**Re: 4071.10 – The Asylum – Level III Development Review Application
Response to City Staff Comments**

Below are our responses to staff comments that you provided to us on April 14 for the proposed Asylum project.

J5 NEW ADA RAMP

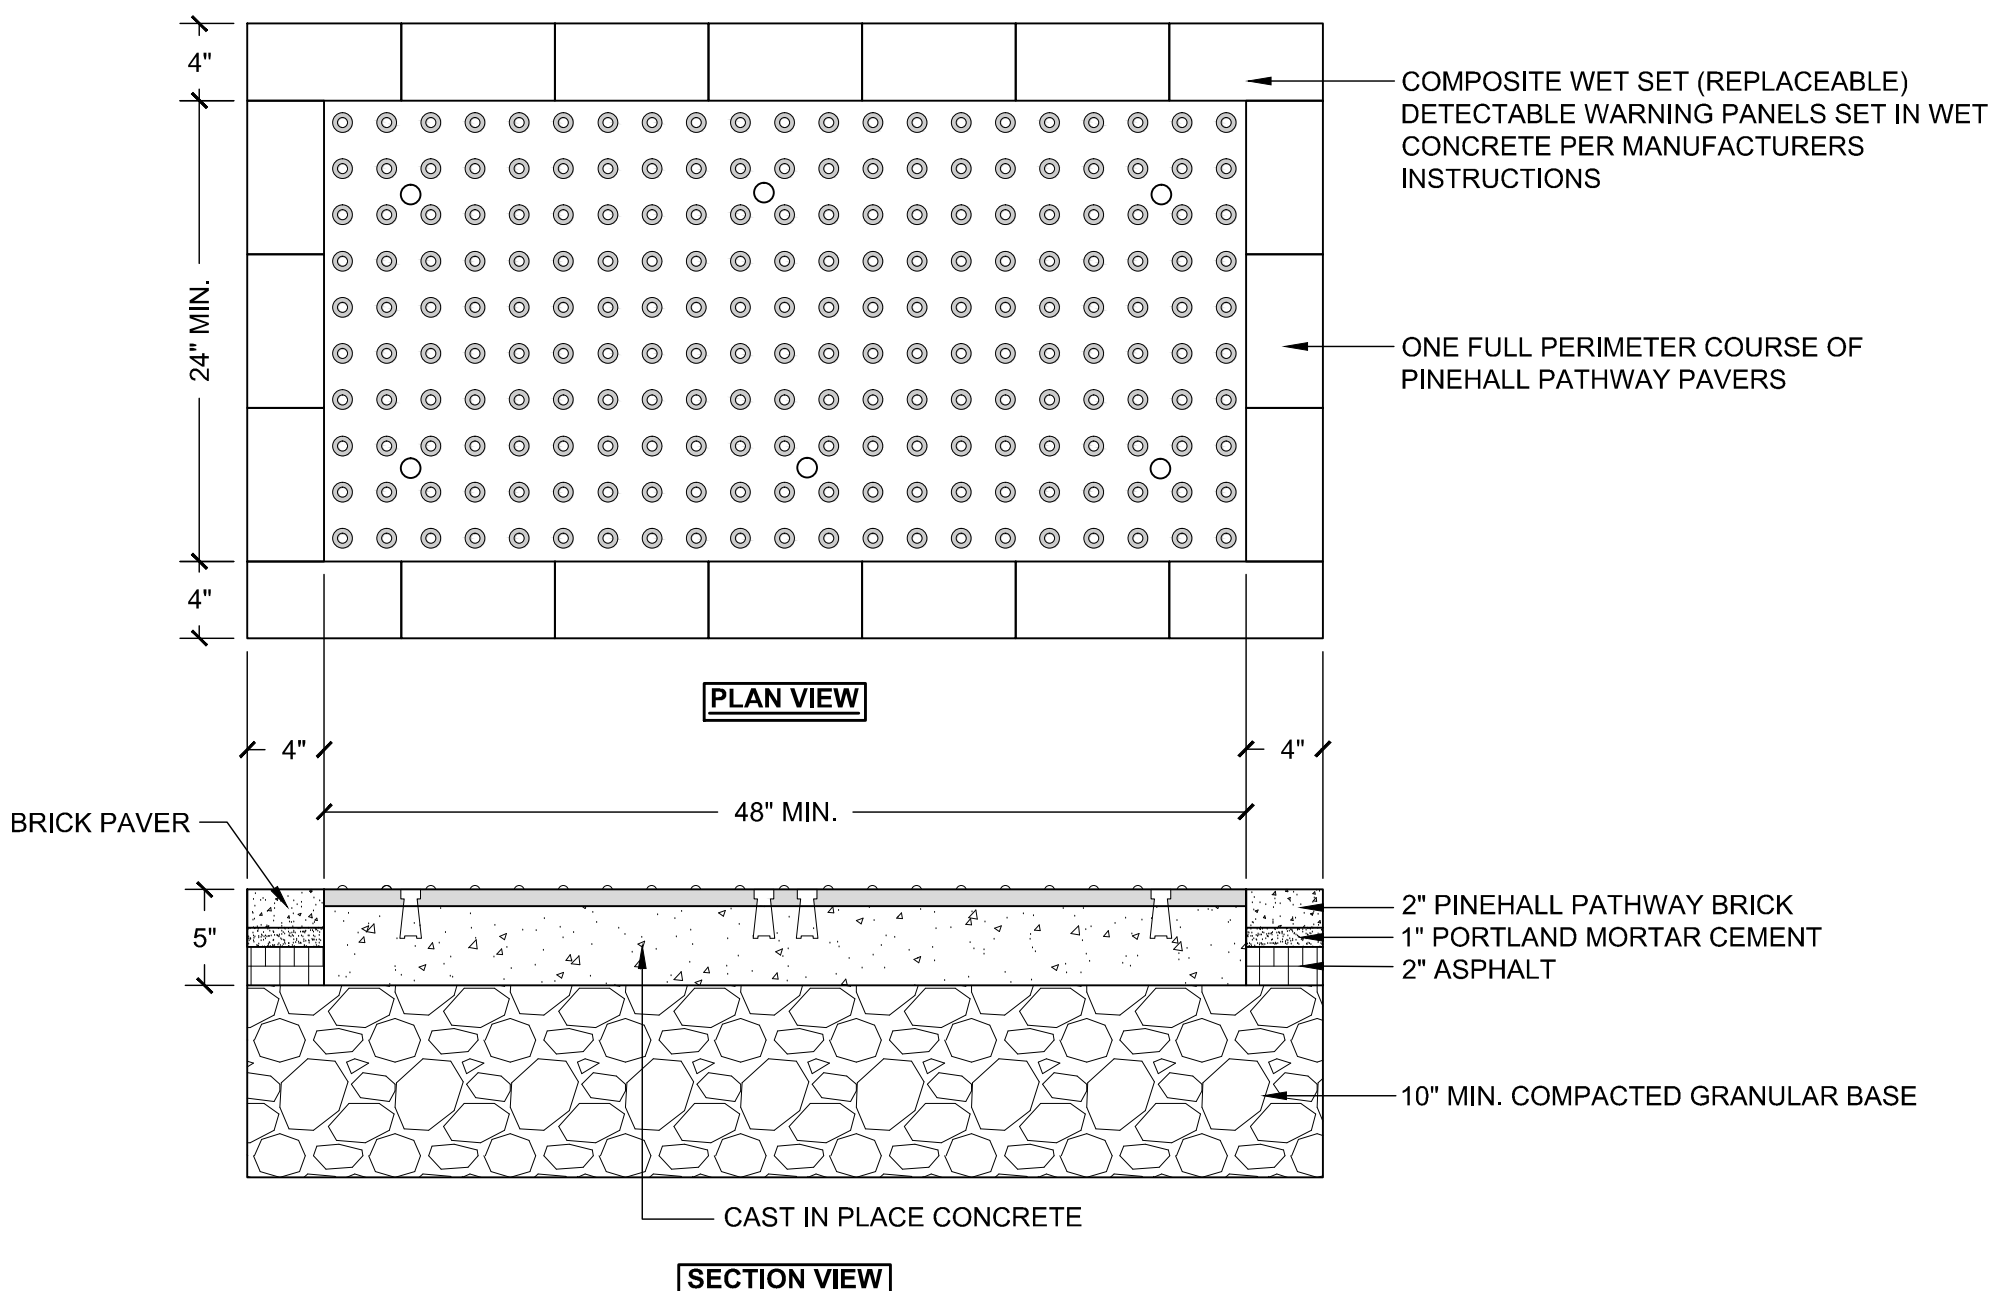
6. Sidewalk ramps must meet City standards. City does not use a clay brick ramp. Check City technical standards. **The detail for the ADA ramp (A1/C503) is consistent with the City's Sidewalk Ramp Detectable Warning Panel (Historic Districts and Landscapes) (I-7A). The label on sheet CP101 – Site Layout Plan has been revised to clearly indicate ramp design.**

SHEET TITLE:
CANOPY SKETCHES

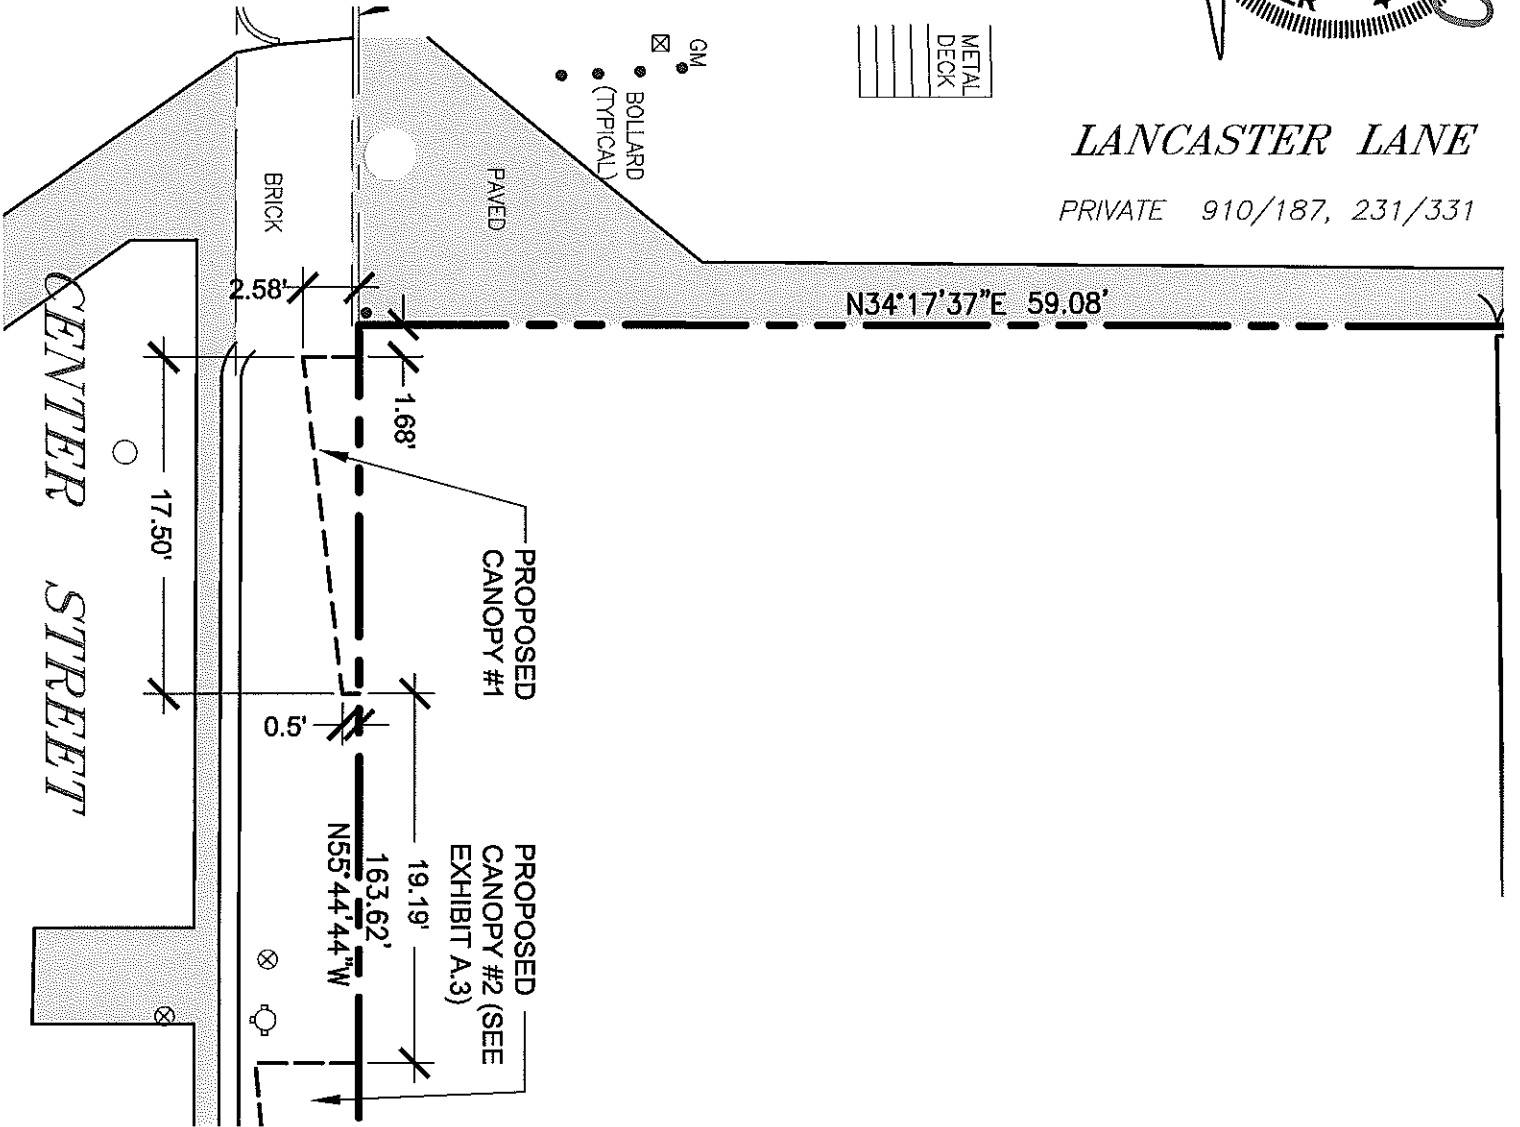
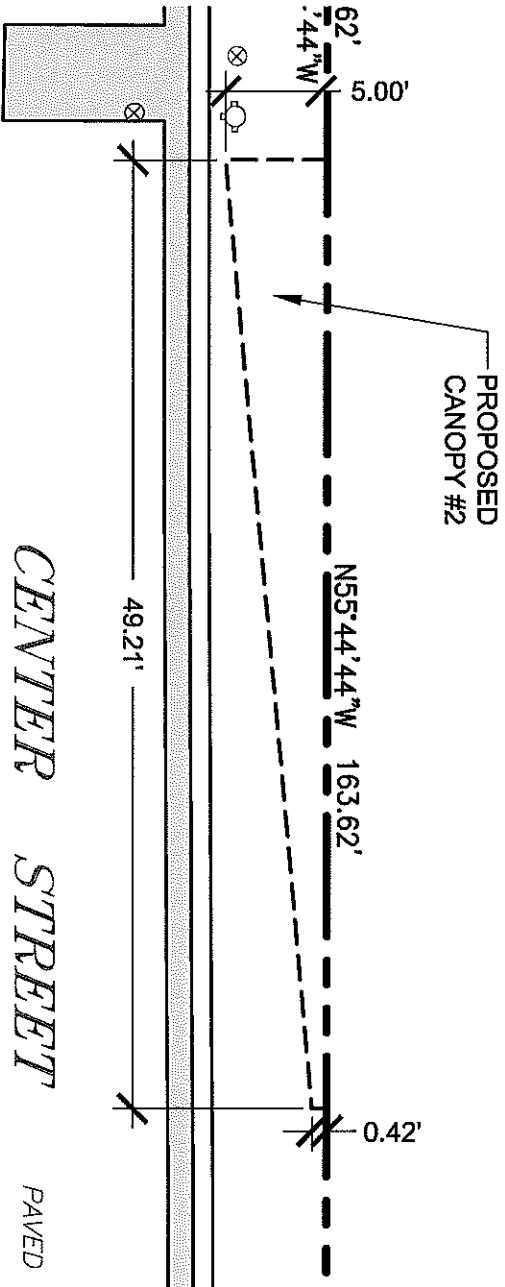
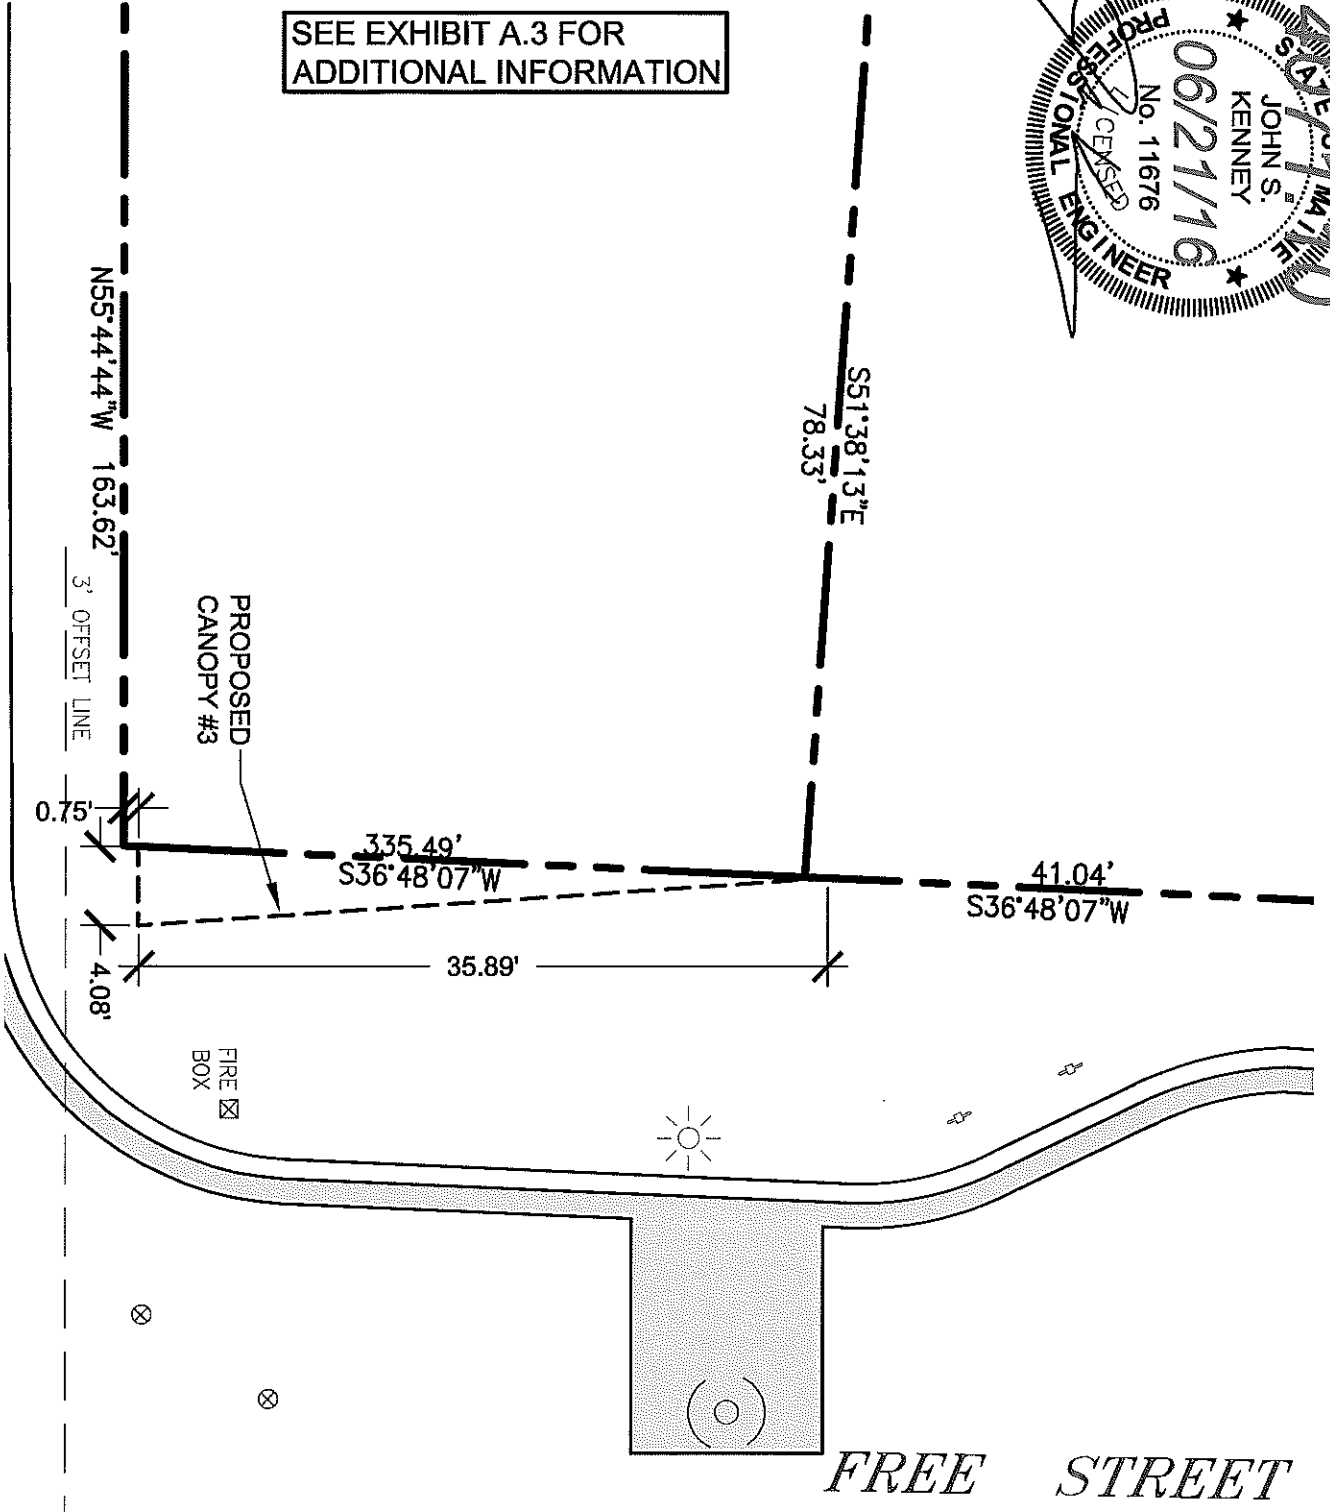
2. Provide more info on the canopies that stick out into the street r-o-w. The Center Street one is particularly large. For example, the materials, design and minimum clearance height for pedestrians **All three canopies will be design to look and act the same, but will be of varying lengths as outlined below. The canopy material will be a light grey colored metal panel on the fascia and soffit.**

Sports Bar Canopy: Canopy is designed at 8'-6" clear above the sidewalk, is 21'-9" in length and protrudes 2'-6" the Lancaster Lane side and tapers to 1'-0" at the other end.

Main Entry Canopy: Canopy is designed at 12'-0" clear above the sidewalk, is 49'-6" in length and protrudes 5'-0" at the Lancaster Lane side and tapers to 4" at the other end.

Free Street Canopy: Canopy is designed at 8'-6" clear above the sidewalk, is 56'-8" in length and protrudes 4'-0" at the Center Street side and tapers to 1" at the other end.
